Application No: M/21/21/HH
Site Address: 34 Sea Lane Middleton-On-Sea PO22 7RT
Description of works: Single storey rear extension and loft conversion.

Thank you for your internet representation made on 11th March 2021 which has been recorded as an objection with the comments as follows:

DRAWING
PROPOSED
ELEVATIONS
DRAWING No
335/07
REVISION
SCALE 1:100
DATE FEB 2021
DRAWN LA
CHECKED

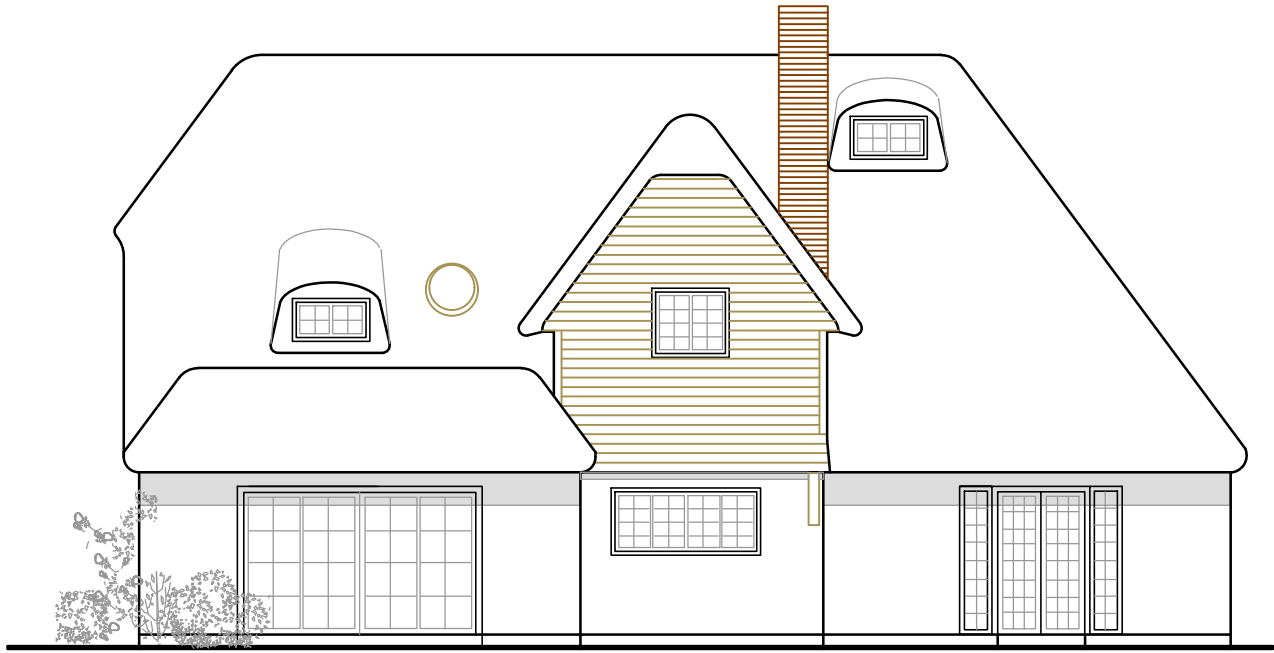
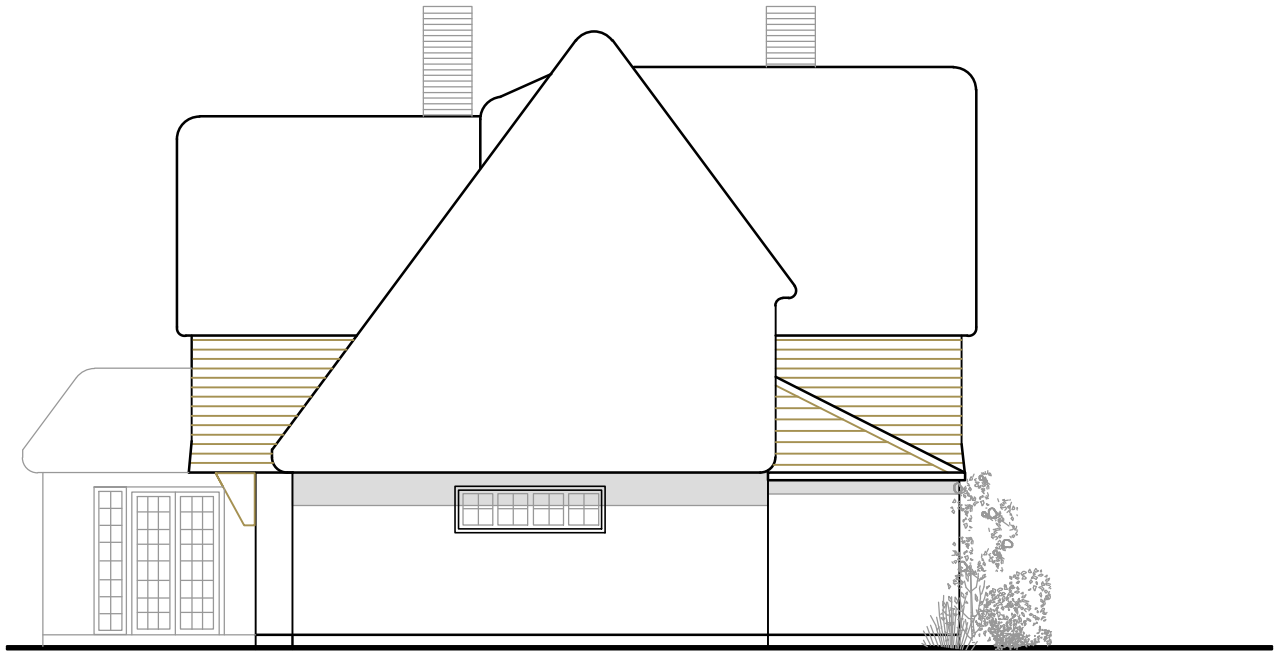
1. It infringes the late Captain Coldicott's original scheme for the estate comprising several cottages with sloping roofs and 1st floor accommodation built into the eaves.
2. It is also inconsistent with the Village Design Statement.
3. The proposed high level eyebrow window on the south-west elevation is visually unappealing because it distorts the thatched roof on the western elevation of the property, and
4. That window would provide a GRANTSTAND VIEW OF OUR REAR GARDEN, albeit at an angle, and as a result will REMOVE THE PRIVACY OF OUR BACK GARDEN.
